EN010085 - Application by Cleve Hill Solar Park Ltd for an Order Granting Development Consent for the Cleve Hill Solar Park

RE: Advice Following the Issue of Decision to Accept the Application for Examination

Table 1 - Applicant's Response to Inspectorate's Observations

Cleve Hill Solar Park Limited

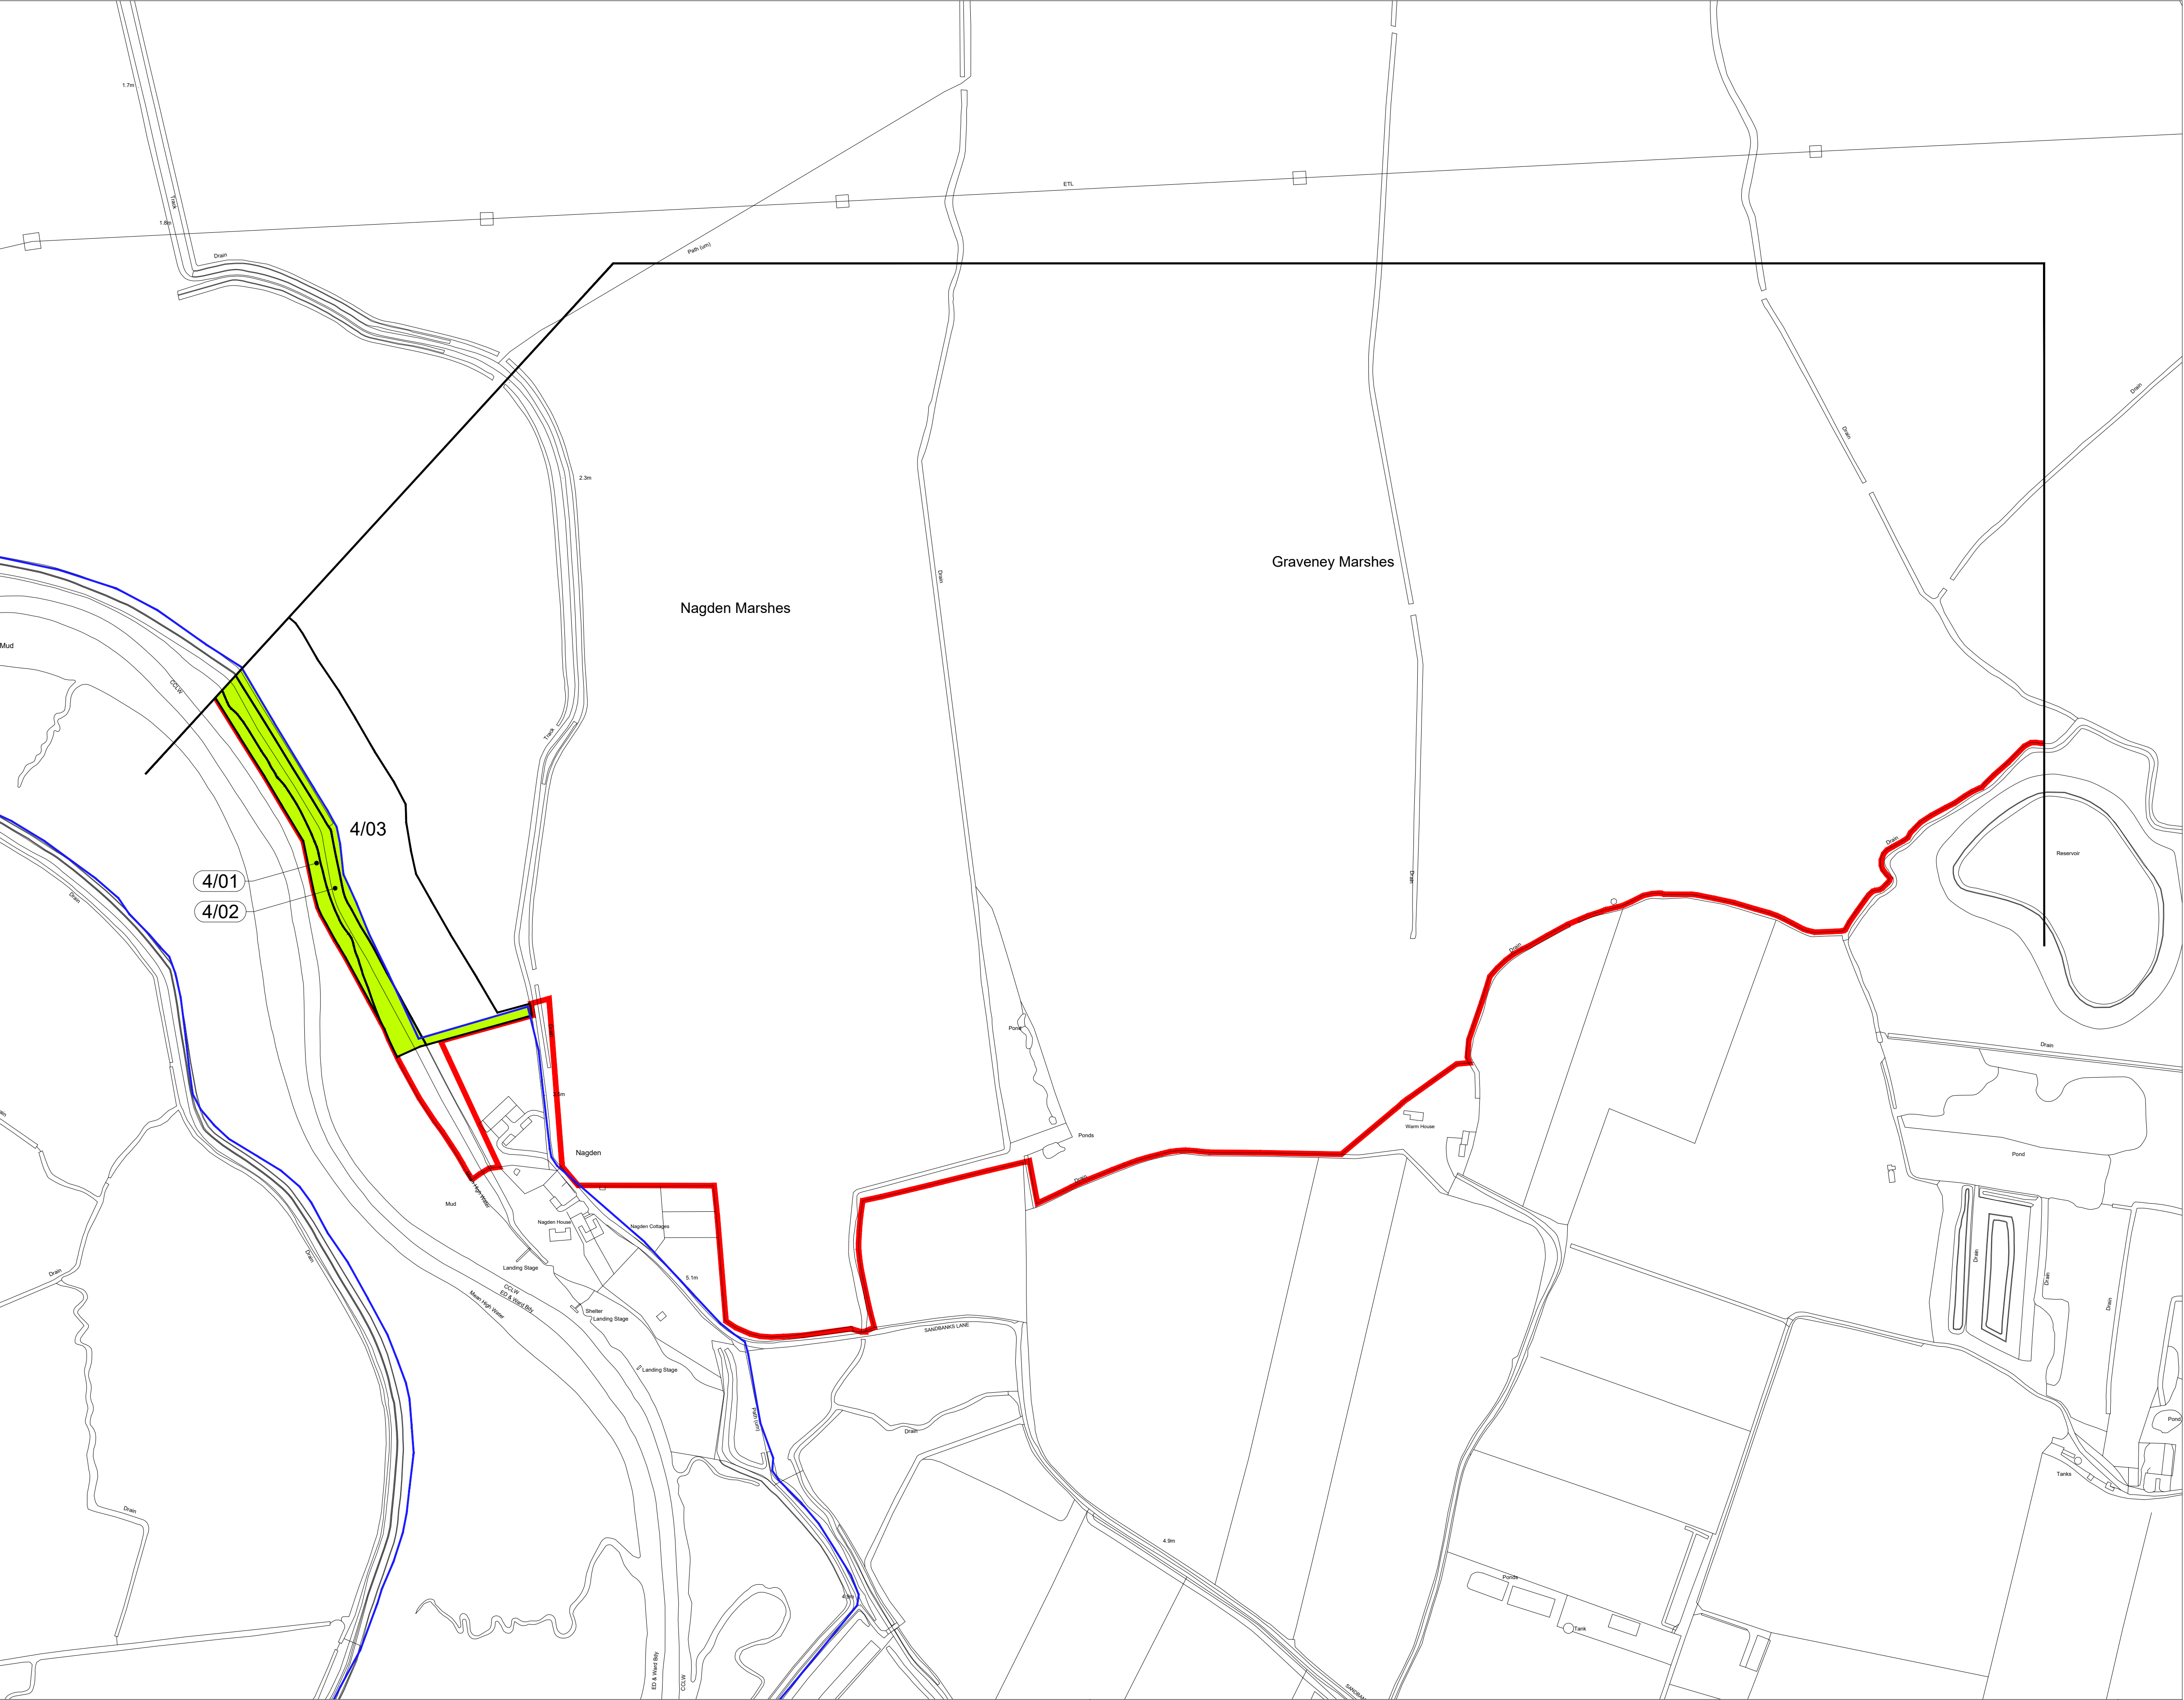
<p>Special Category Land Plans:</p> <ul style="list-style-type: none"> • Some plots (1/08, 2/02, 3/02A, 3/02B, 3/10) are subdivided (only a given area of a plot is used for 'open space'). • Plot 1/08 states in the Book of Reference – part 5 that only a part of the plot is required, all other plots where only part of the plot is depicted on the plans as needed for 'open space' just state the plot number. Plots 4/01 - 4/03 in the Book of Reference are not separately identified on the plans 	<p>This is correct, the Open Space Land Plan details the part of the plots that are considered to be open space.</p> <p>Part 5 of the Book of Reference has been updated to make it clear that only part of these plots is considered to be open space.</p> <p>Plots 4/01 and 4/03 were missing on the submitted plans in error. These plots are shown on Revision B of the enclosed Open Space Land Plan.</p>
